PR-2020-004138

SD-2023-00227 – FINAL PLAT

(MONTAGE 7)

REQUEST: SINGLE FAMILY RESIDENTIAL LOT SUBDIVISION

FINAL PLAT OF
MONTAGE 7
TRACT A-1-A-5-C
OF
MESA DEL SOL
INNOVATION PARK

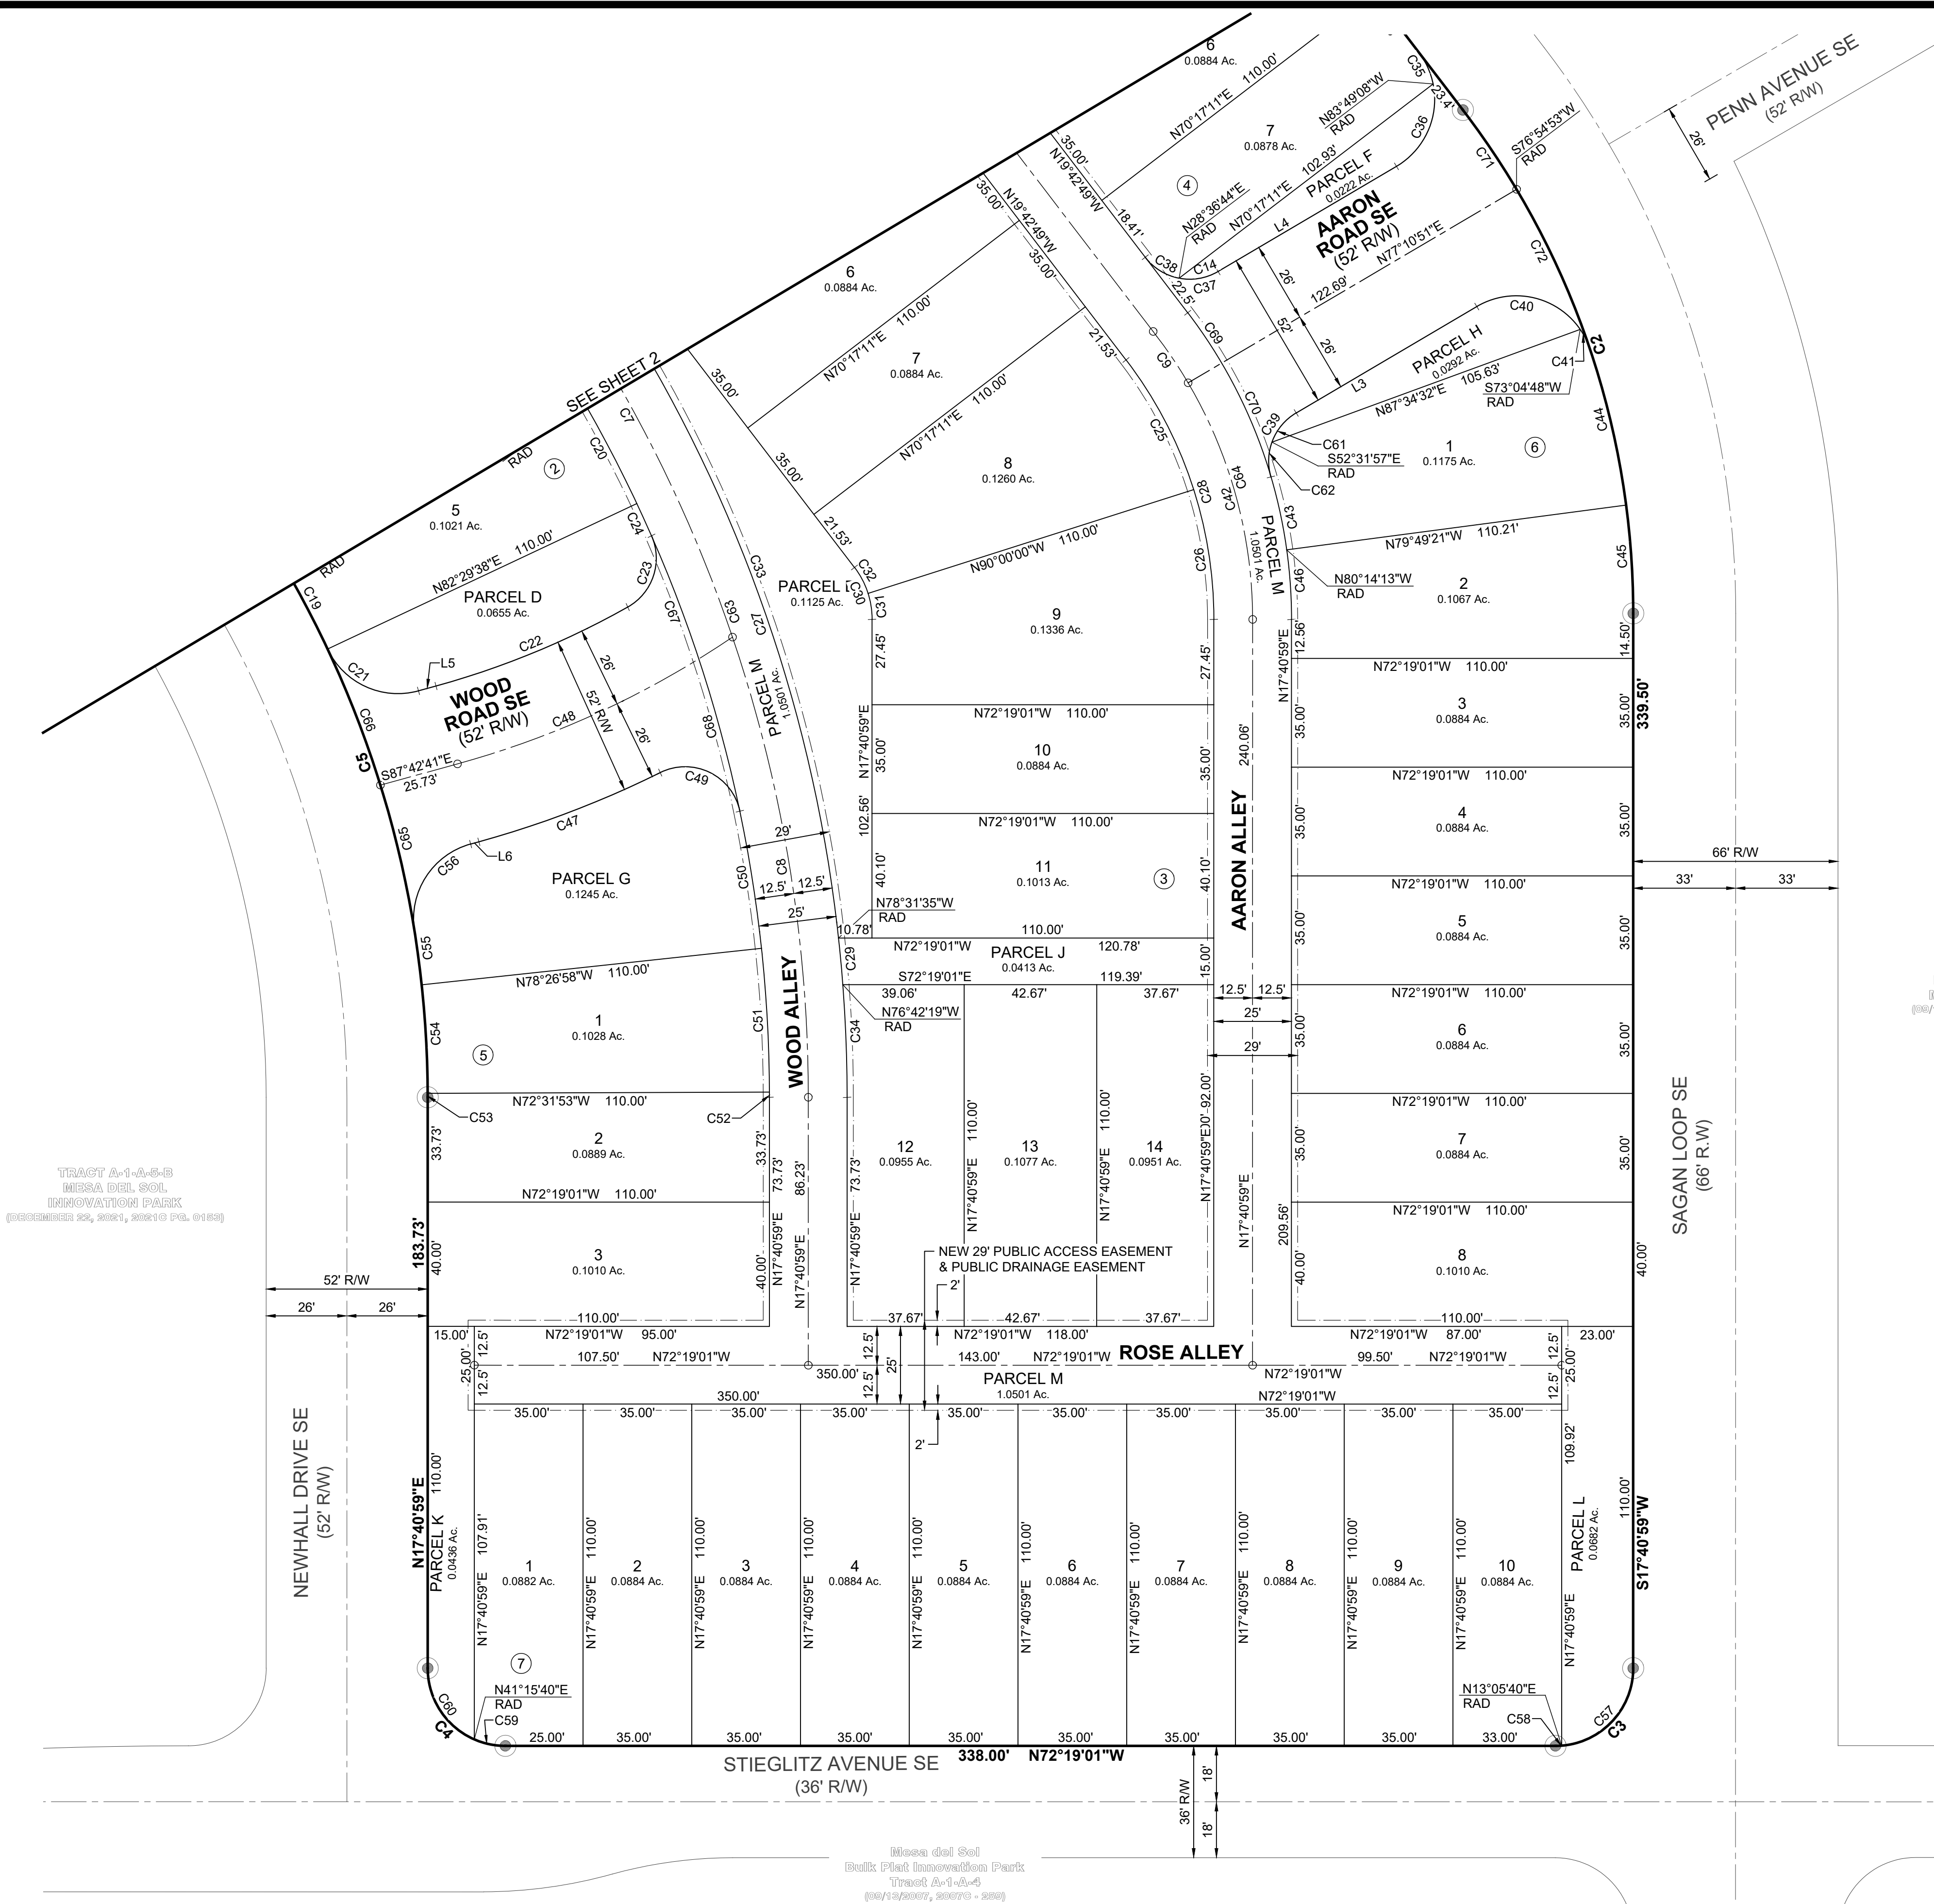
- The application number on the Plat must be corrected to SD-2023-00227.
- The DXF file must be approved by AGIS, and the approval email from AGIS must be submitted prior to final sign-off from Planning should the Plat be approved by the Development Hearing Officer.

NEW ABCWUA EASEMENTS

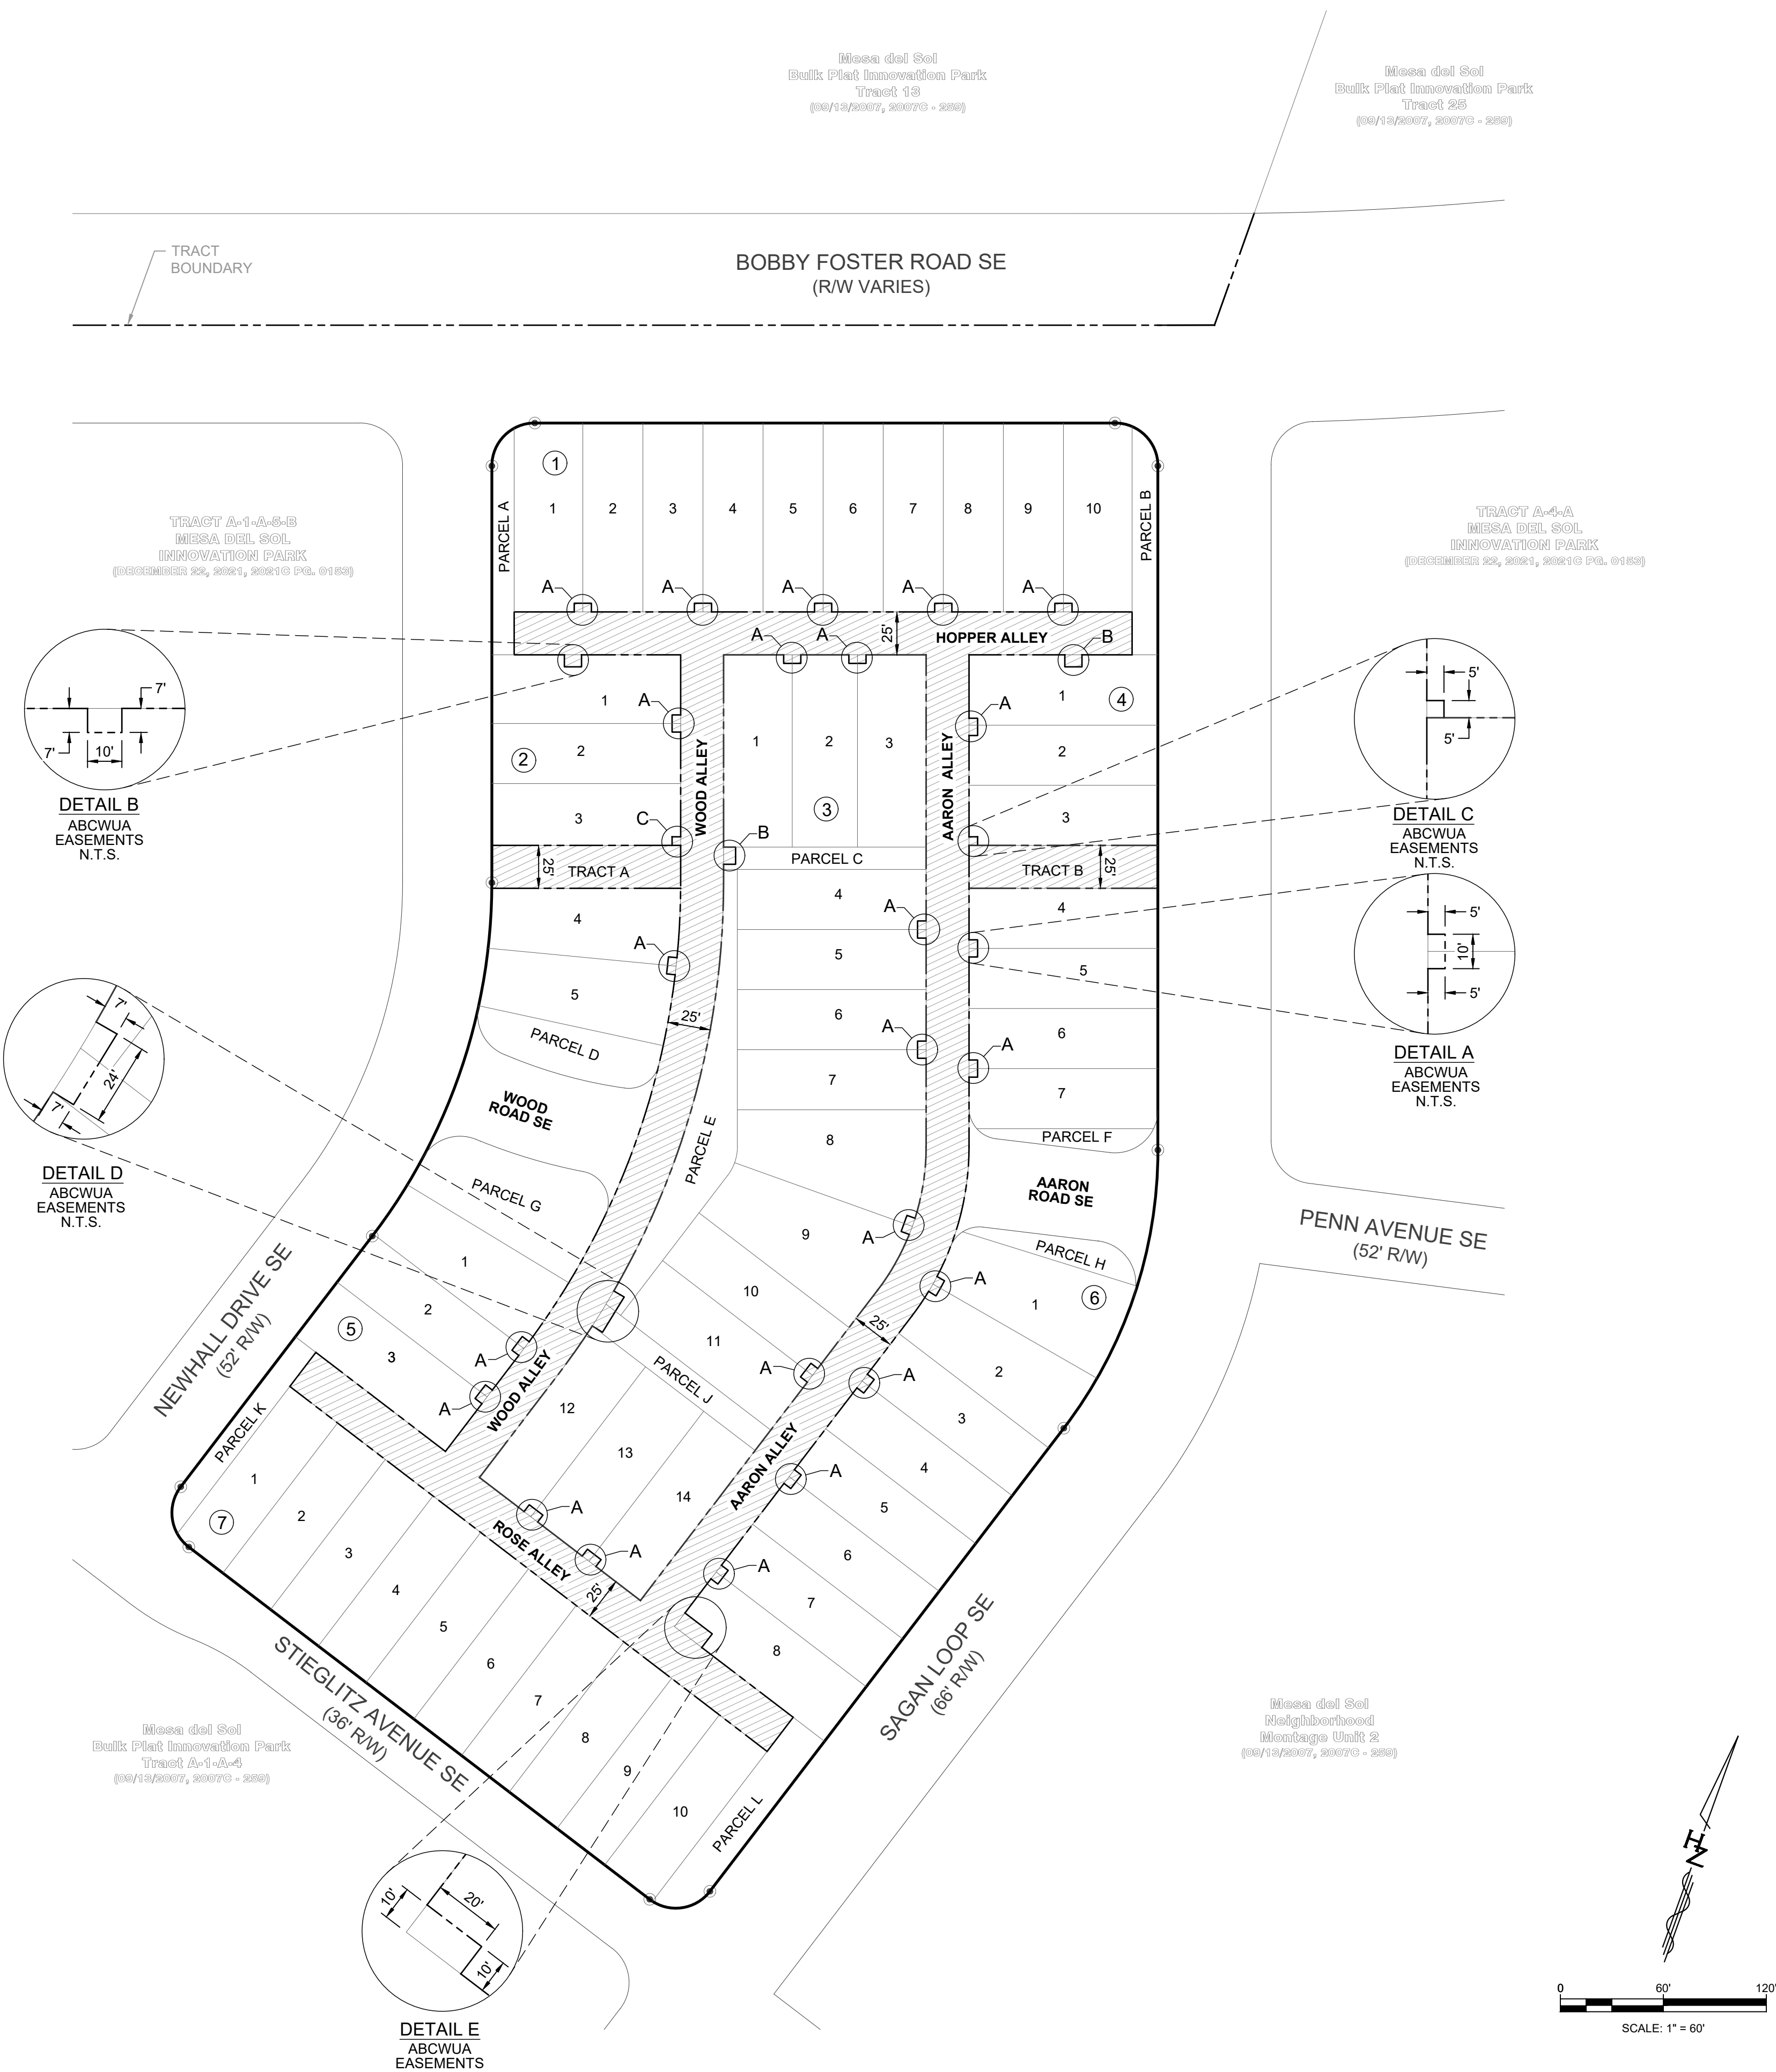
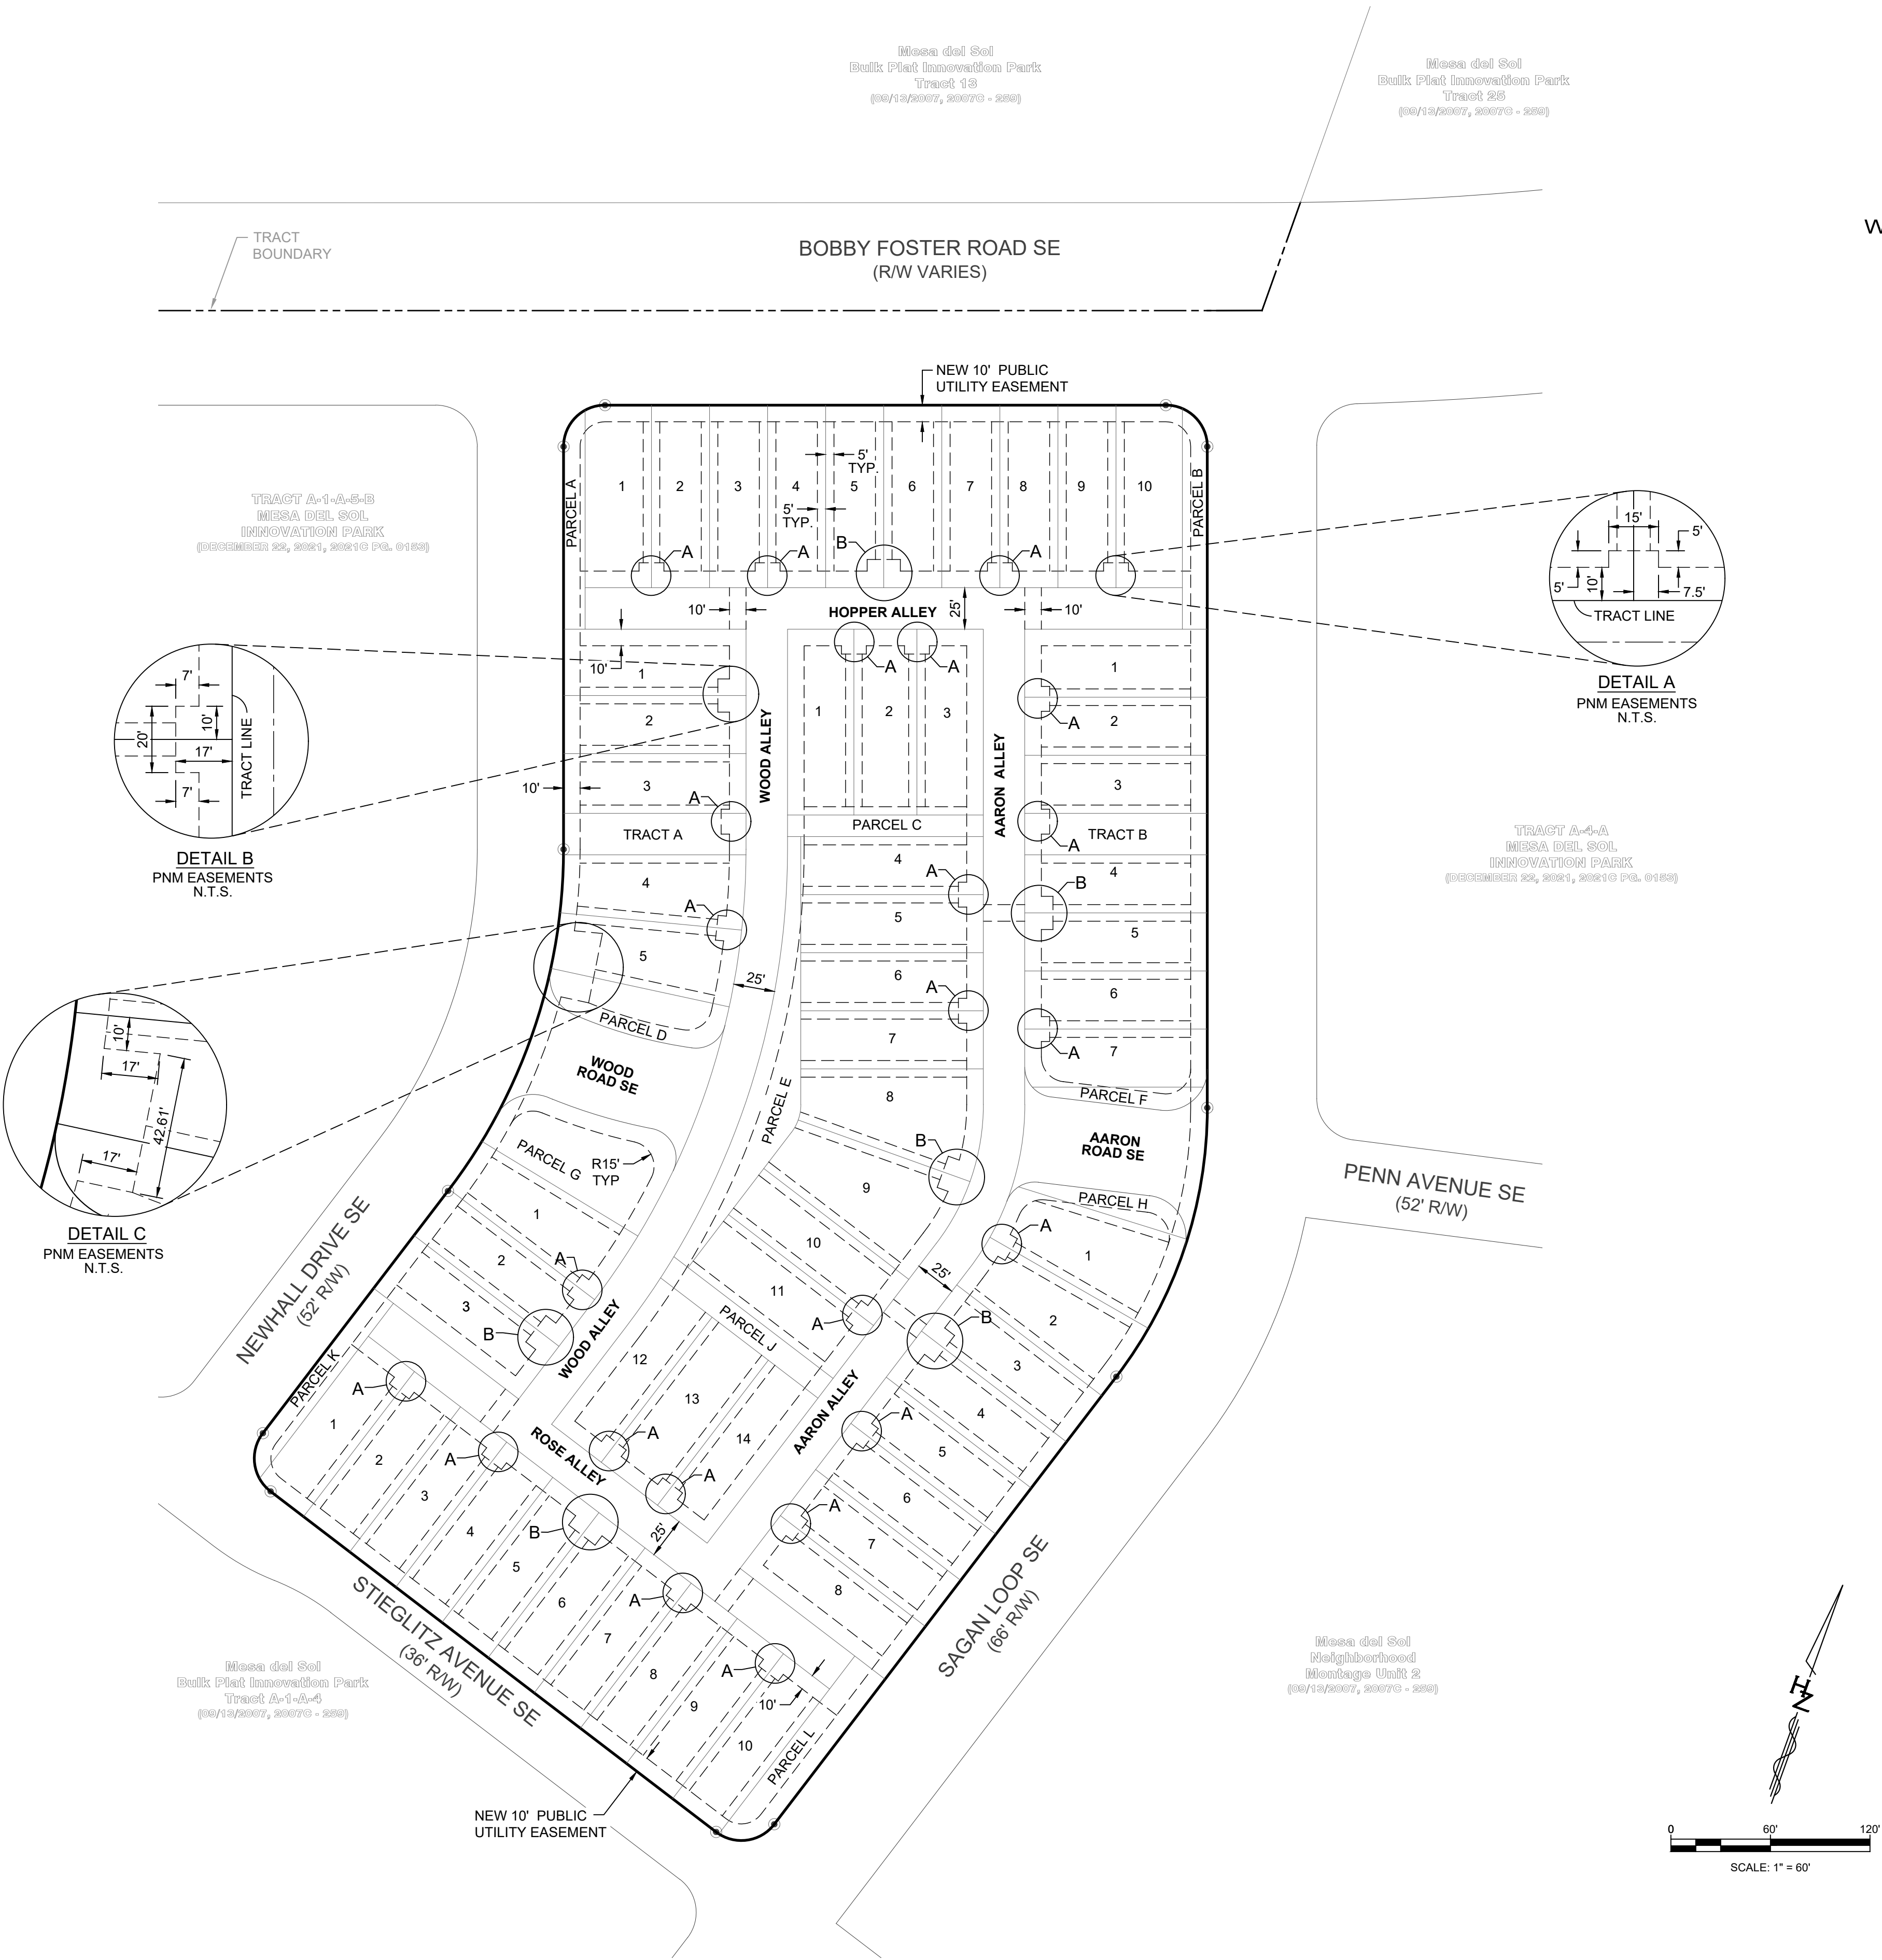
- 7. The proposed plat needs to identify specifically public water and public sanitary sewer easements along the tracts appropriate within the subdivision.
 - a. Please confirm that Tract M is the tract that will house this infrastructure.
 - b. For small bump out easements, an exhibit along with Tract M will need to be provided to ensure this is shown in a single exhibit to house the public water and public sewer infrastructure proposed.
- 8. Please add the following note to the cover sheet of the plat.
